Meeting note

Project name	Riverside Energy Park
File reference	EN010093
Status	Final
Author	The Planning Inspectorate
Date	27 September 2018
Meeting with	Cory Riverside Energy (CRE)
Venue	TQH, Bristol
Meeting objectives	Review of draft application documents
Circulation	All attendees

EN010093 RIVERSIDE ENERGY PARK

EN010093 Riverside Energy Park. Draft Documents ES Review. Chapter 3 Site and Project Description.

Plate 3.19: Example temporary trenchless installation compound (illustration is of a typical HDD setup)

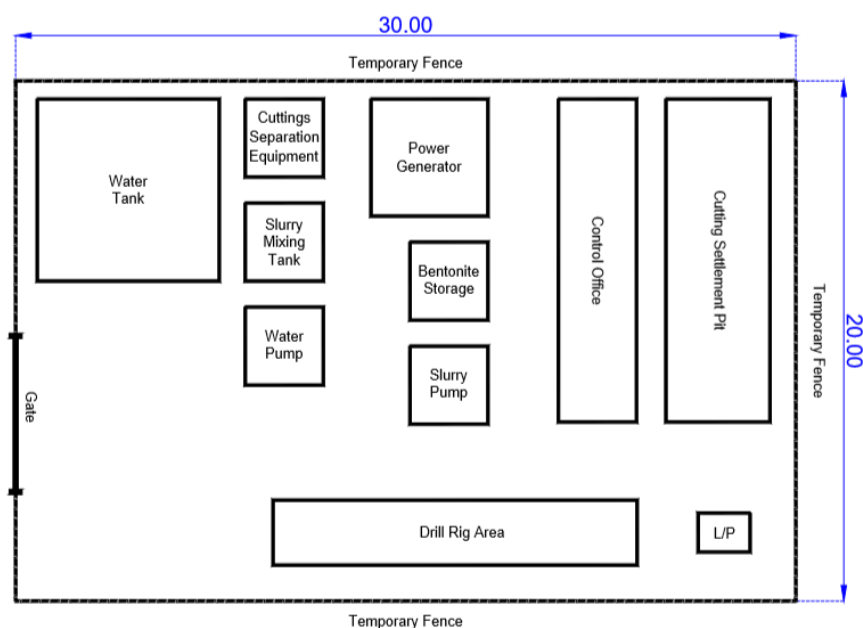
3.5.32	Trenchless installation	Is this confirmed to be possible? If it may not be possible then alternatives methods of installation should be discussed.
